Item No. **Report of the Head of Planning, Building Control, Sport & Green Spaces**

Address LIDI STORE, 482 UXBRIDGE ROAD HAYES

Development: Single storey extension and alterations to elevations

LBH Ref Nos: **26168/APP/2014/2028**

& POOLE PATTLE chartered architects			
Project LIDL, 482 UXBRIDGE ROAD, HAYES UB4 0SD		Date JUN 2014	Scale 1:200 @ A1
Drawing SITE LAYOUT AS PROPOSED		3230	5_01 B
© This drawing must not be reproduced in whole or part without written consent.

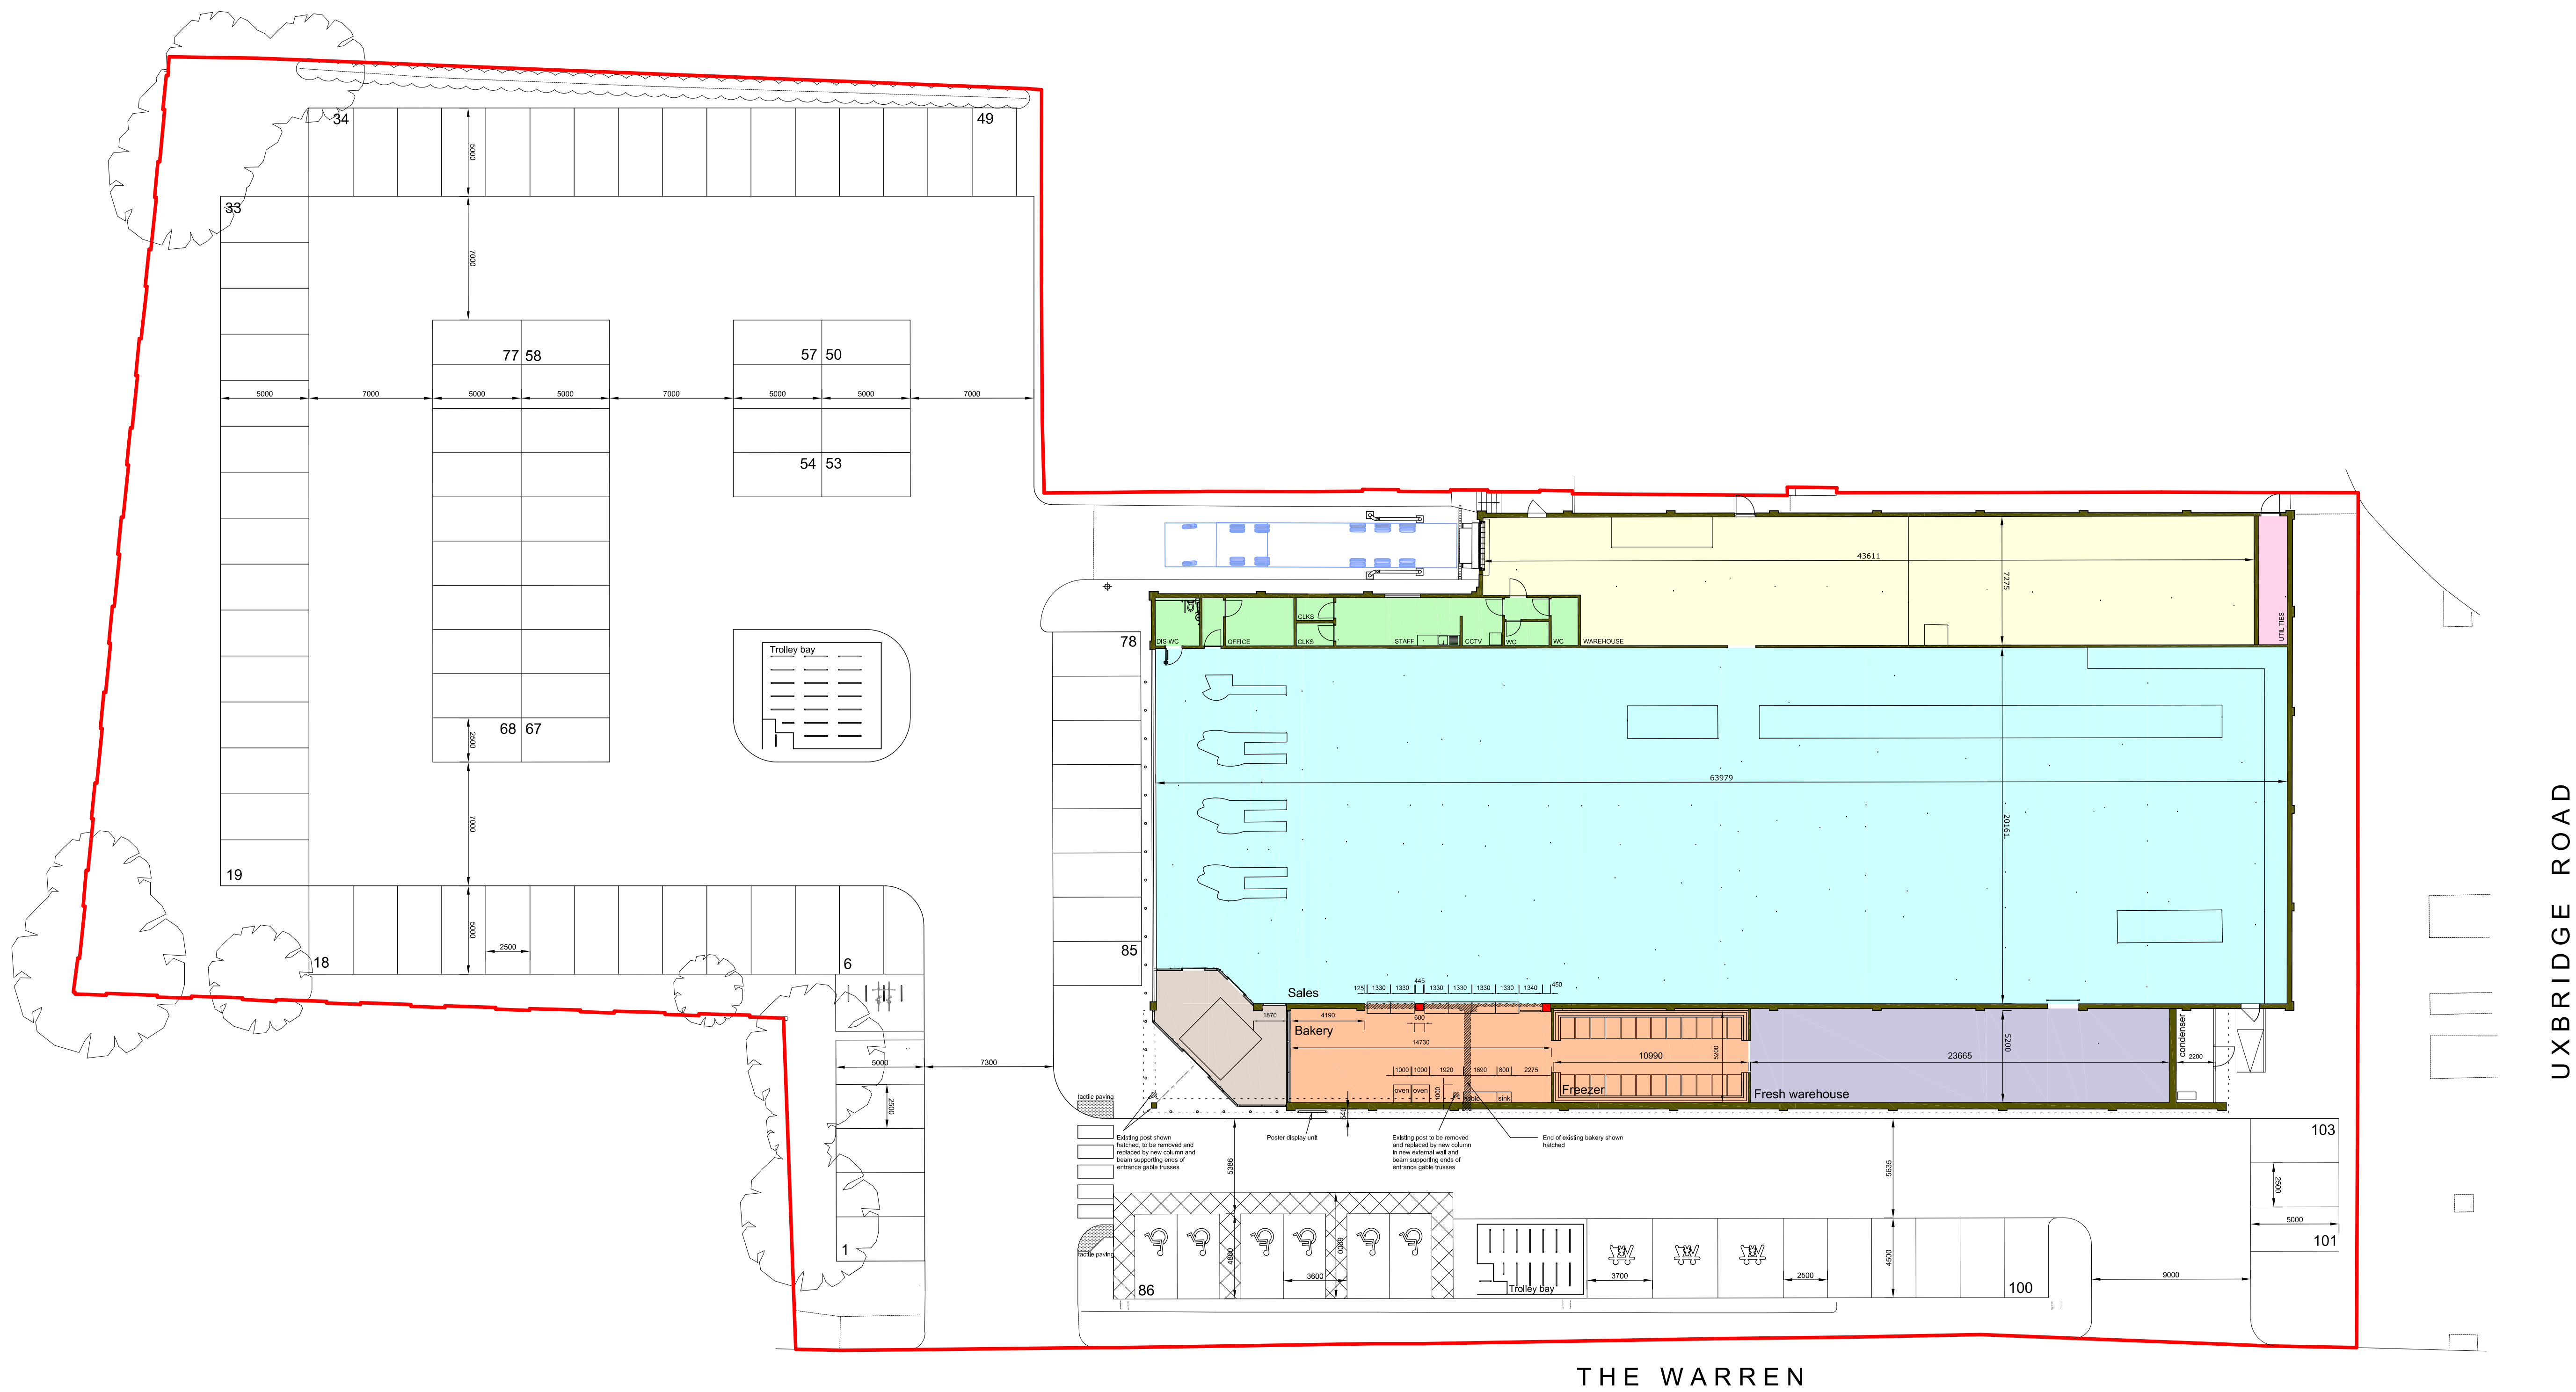
The proposed extension and revisions to the existing car park layout would result in the loss of 20 car parking spaces from the site (from 123 to 103 in total). The previously allowed scheme, now constructed, resulted in the loss of 14 car parking spaces.

It should be noted that in the past when the retail store was granted planning permission, it was considered that the original car parking provision was required. A subsequent extension to the store resulted in a loss of some 14 car parking spaces. A further 20 spaces would be lost as a result of this proposed scheme.

The Highways Officer has raised an objection in respect of the application. He has advised that in the past when the retail store was granted planning permission, it was considered that the original car parking provision was required. A subsequent extension to the store resulted in a loss of some 14 car parking spaces. A total of 20 spaces from the existing site layout would be lost as a result of this proposed scheme.

The applicants have failed to provide information on the actual parking demand and a survey is required to demonstrate this demand to demonstrate that the net loss of 20 parking spaces would not lead to an increased demand for off-site parking which could be prejudicial to highway safety.
